From: Piers Carlisle | Haines Phillips Architects [REDACTED]
Sent: 03 June 2020 10:28
To: Zac Denton <[REDACTED]>
Cc: Martyn White [REDACTED]
Subject: Re: AB/32/20/DOC - Clarification

Please find attached drawings for yours and Mr White's attention in answer to his queries relating to the above Application to Discharge Conditions. I shall address these below:

This application is regarding your Discharge of Conditions application at Old Wheatsheaf House, 31 Maltravers Street.

DRAWING TITLE
**Basement Plan
Proposed**

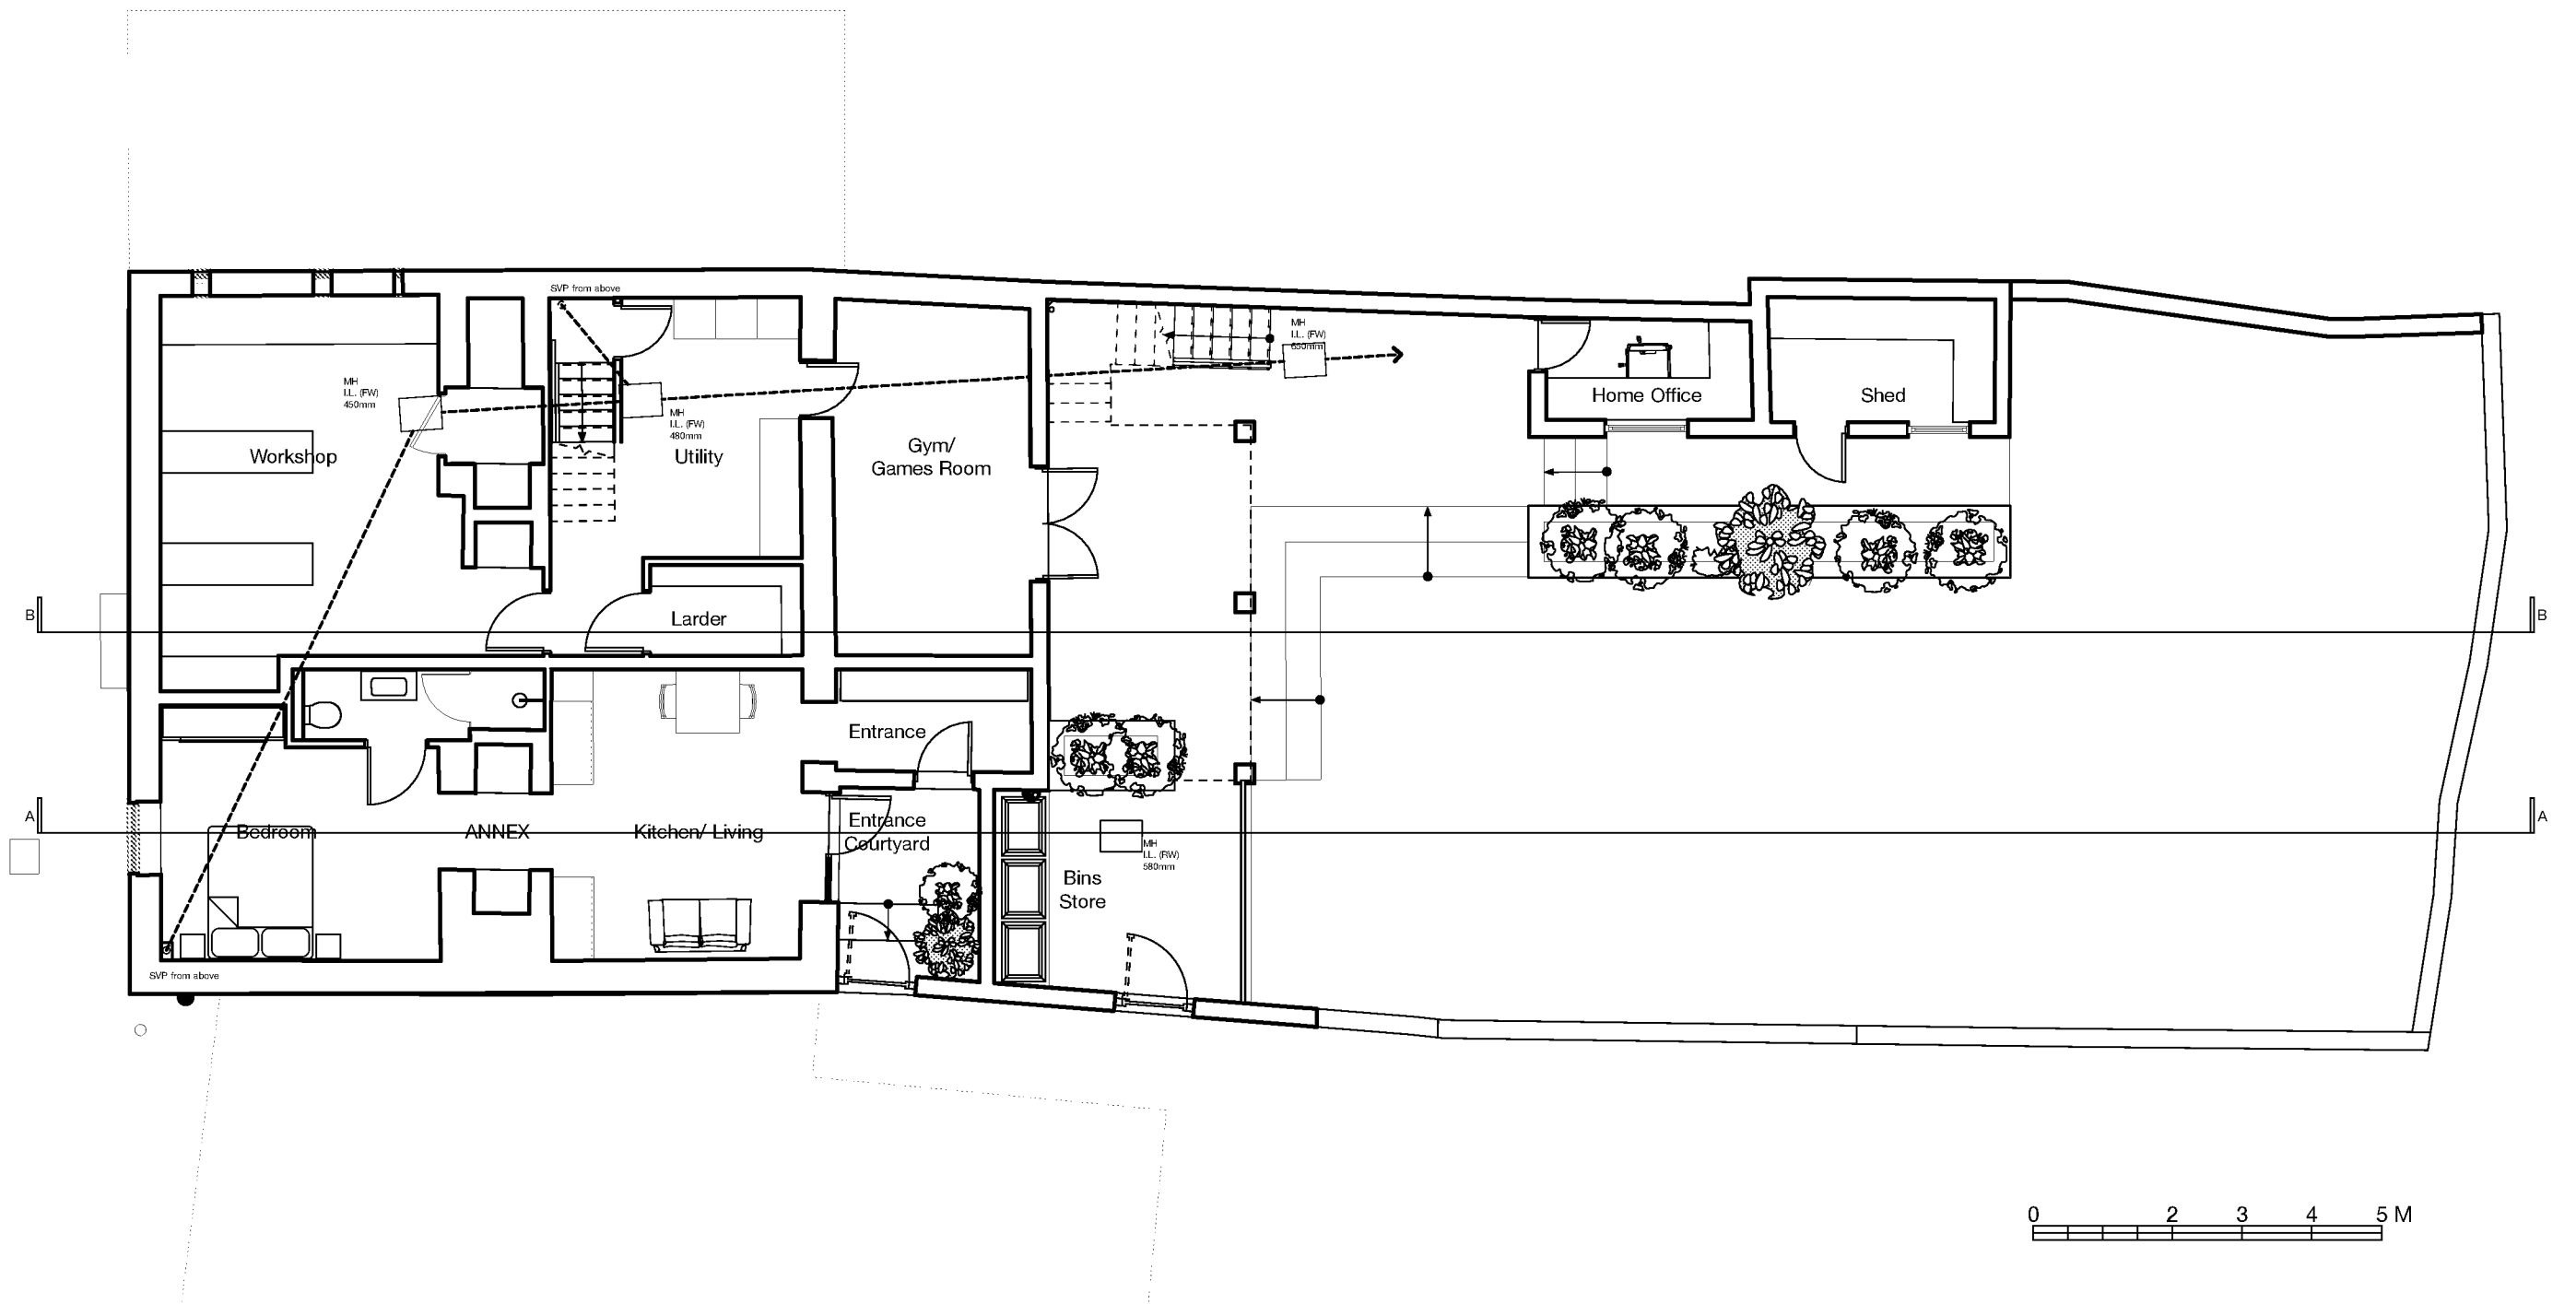
Door type B – there were some changes to the layout in the Annex but this has now reverted to the original layout. However, a French door with a side-panel is to be fitted in this location, rather than the double French doors originally shown in the Planning and Listed Building applications. This was to reduce the increase to the width of the opening. The side-panel is now side-hung. The entrance door to the Annex is a Type A door – as originally intended in the original Planning and Listed Building applications.
